ENG-CDR20005-V2-CDs-Vollmer-Redlines.pdf Markup Summary

1 (5)

**VOLLMER ROAD**  
**STA 10+00.00 TO STA 23+50.00**

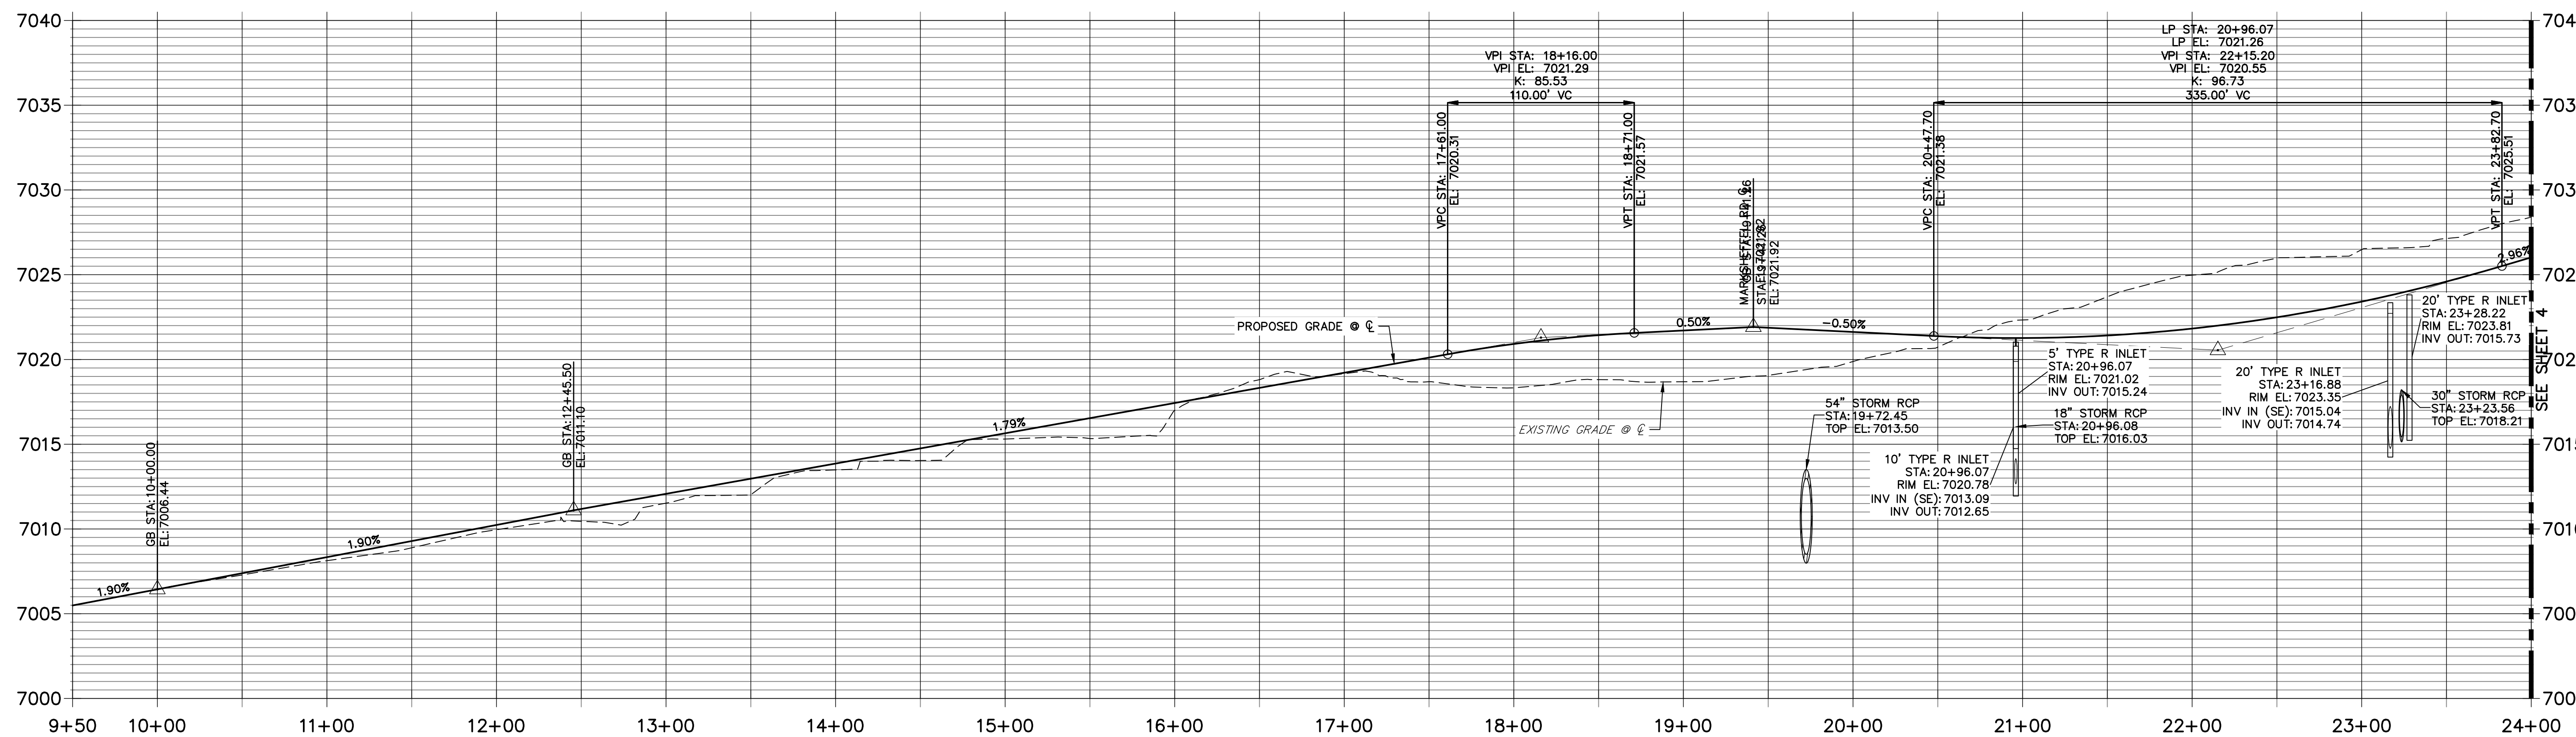
see comment letter regarding curb & gutter

should inlet be in ultimate location?
